Re: Planning Application 18/1085

Address: 12 Bushburn Drive Langho BB6 8EZ

Description: Rear dormer conversion and alterations to front porch.

PROPOSED PARKING DETAIL SCALE 1:100 @A1

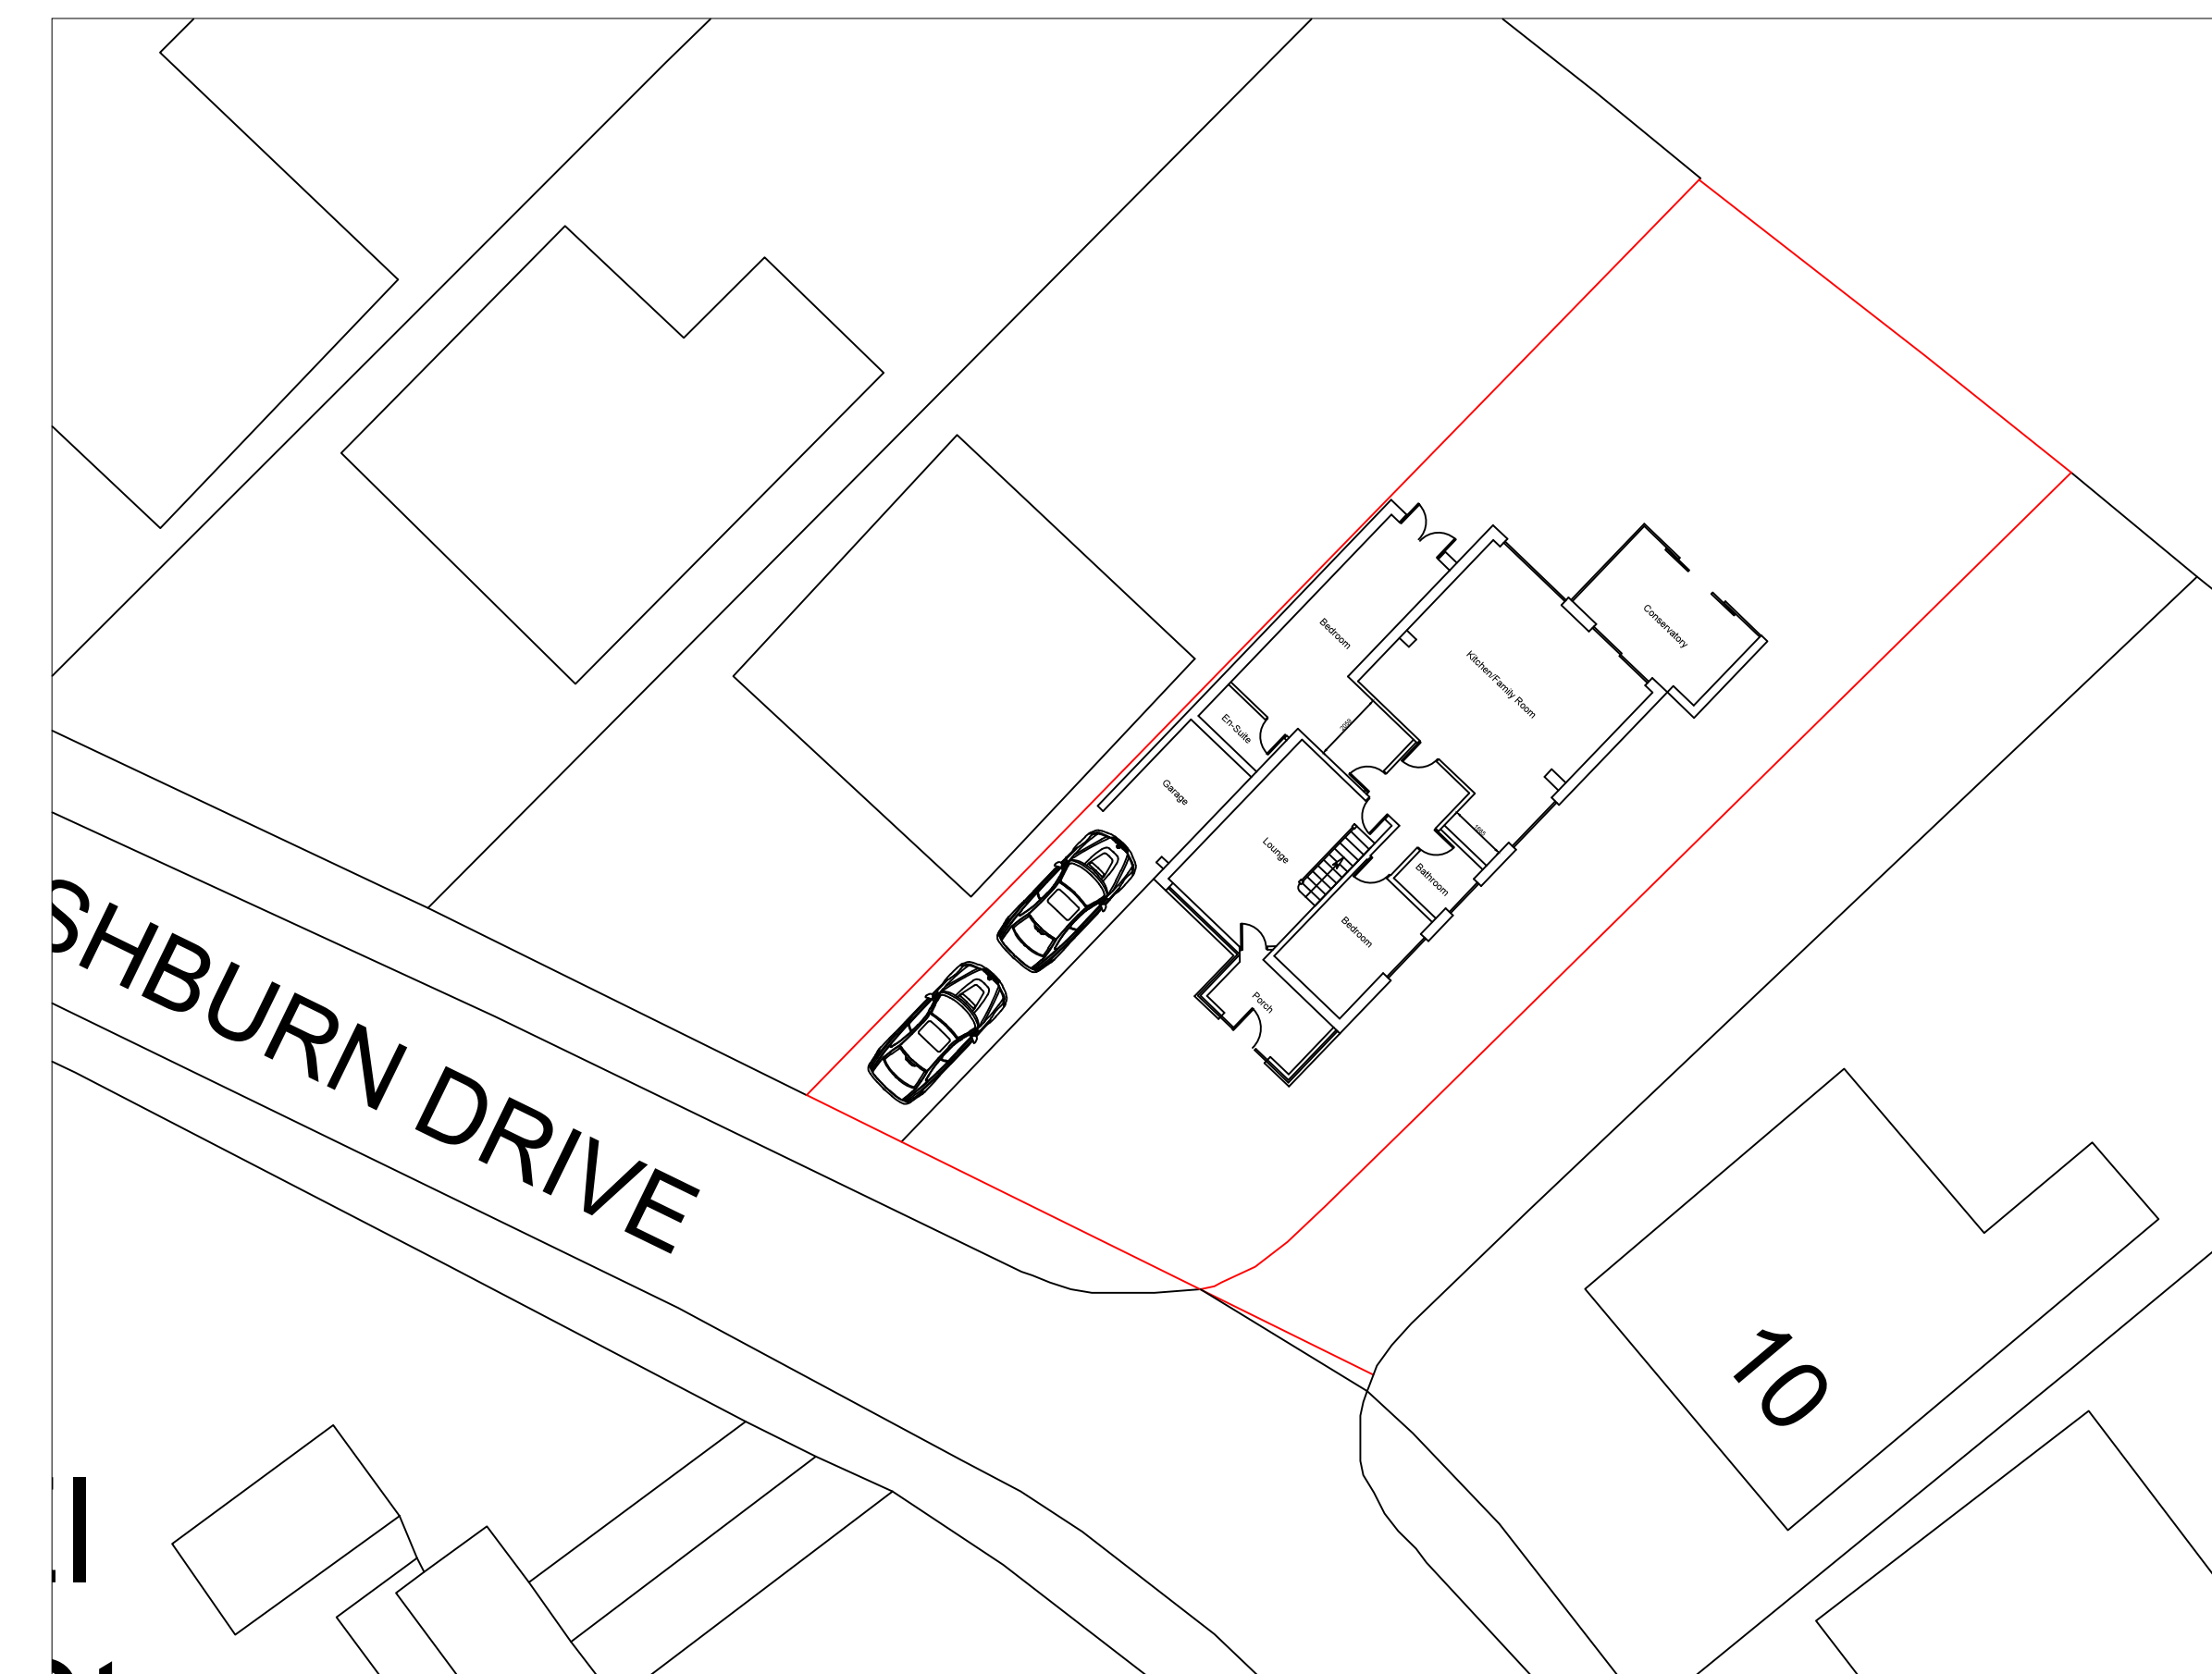
The proposed work will increase the dwelling to a 5 bed roomed house, which in line with Lancashire's Parking Standards would require 3 car parking spaces.

The car parking spaces should be 2.4m x 5m with an additional 0.8m width where the access is also used as the pedestrian access.

In order to progress the application we would look for further plans indicating how the required parking spaces can be provided. It is expected that there will be a requirement for an extension to the dropped crossing.
